**BUILDING CODE OF AUSTRALIA
REPORT**

**Eastern Creek Retail Centre
Rooty Hill Road, Eastern Creek**

BCA ASSESSMENT REPORT
Proposed Retail Centre
Rooty Hill Road, Eastern Creek

Drawing No.	Title	Date	Drawn By	Revision
DA05	Proposed Stage 1 Plan	01.09.17	I2C	A

PROPOSED STAGE 1 PLAN 1 : 500

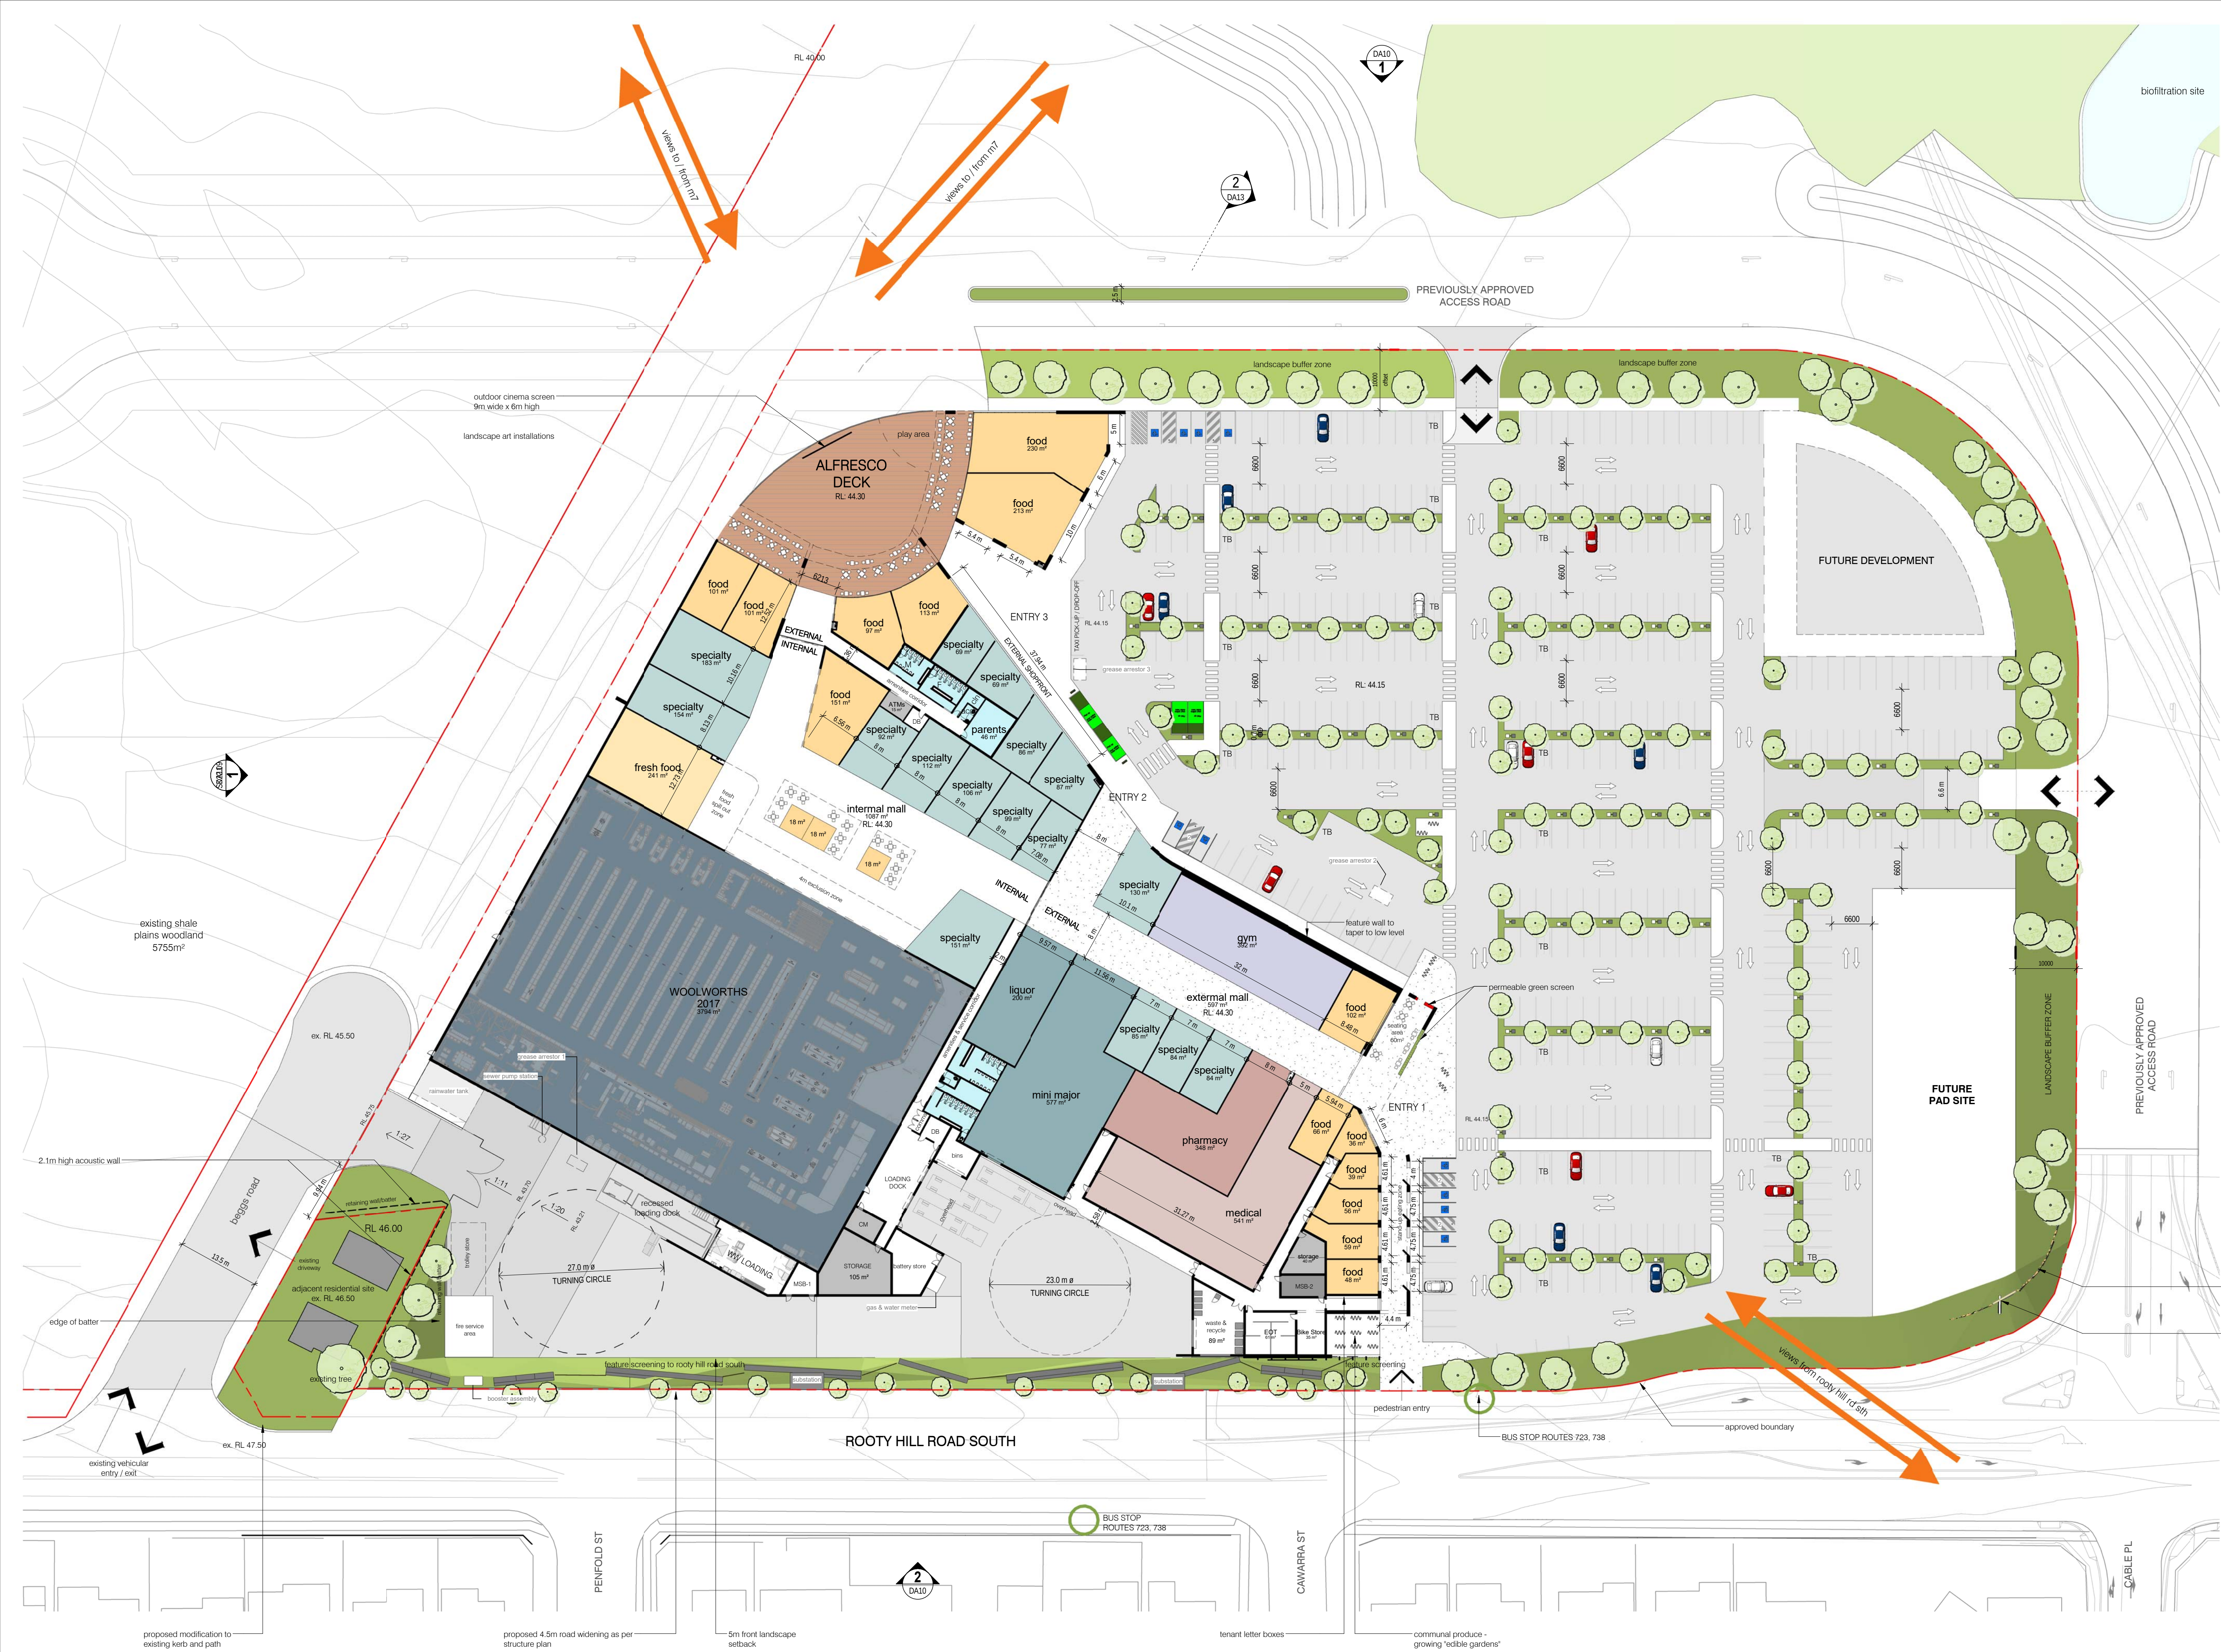
DTS Clause	Description of Non-Compliance	Performance Requirement
C2.4	<p><u>Perimeter Vehicular Access</u> A minimum unobstructed width of 6m located within 18m is required to the entire perimeter of the building.</p> <p>The North East portion of the building does not achieve 6m clear vehicular access. The access to the south is discontinuous and the south eastern portion has areas where the access is up to 19m from the building and is less than 6m in clear width.</p>	CP9
D1.4	<p><u>Extended Travel Distances</u> The travel distances to exits should not exceed 30m to a single exit or 20m to a point of choice and where two exits are provided, a maximum of 40m to one of those exits.</p> <p>Tenancies located central to the main exits with a maximum of 65m from specialty tenancies and 80m from the Woolworths in lieu of 40m and 36m to a point of choice in lieu of 20m</p> <p>The fire safety engineer is to confirm feasibility of a performance solution to address the above distances.</p>	DP4 & EP2.2

D1.5	<p><u>Extended Distance Between Alternate Exits</u> The distance between alternative exits in a Class 6 building must not exceed 60m. The proposal includes a maximum distance of 100m between alternative exits in lieu of 60m.</p>	DP4
E2.2	<p><u>Smoke Hazard Management</u> It is anticipated that the provision of smoke hazard management will be rationalised throughout the development</p>	EP2.2

It is noted that the building does not contain the required 6m clearance to the north east façade, is discontinuous to the south and has portions more than 18m from the building and less than 6m in width to the south east. In addition further information is required to confirm truck circulation in the southwest loading dock area adjacent to the medical centre.

The vehicular access provided is less than required under C2.4 and therefore a fire engineered solution will be required to address Performance Requirement CP9 of the BCA

- Specialty tenancies located central to the main exits have travel distances up to 65m to an exit, And 80m from the Woolworths in lieu of 40m
- 36m (max.) to a point of choice in lieu of 20m from the parents room/female bathrooms, and 21m from Woolworths

Separation of exits does not fully comply as the distance between alternative exits exceeds 60m, with a maximum of 100m.

The hose reels are currently not indicated on the plans and therefore further detail is required to undertake a full assessment.

Location of pumps, tanks, FIP, control valves and booster are to be indicated on the plans to allow a full assessment
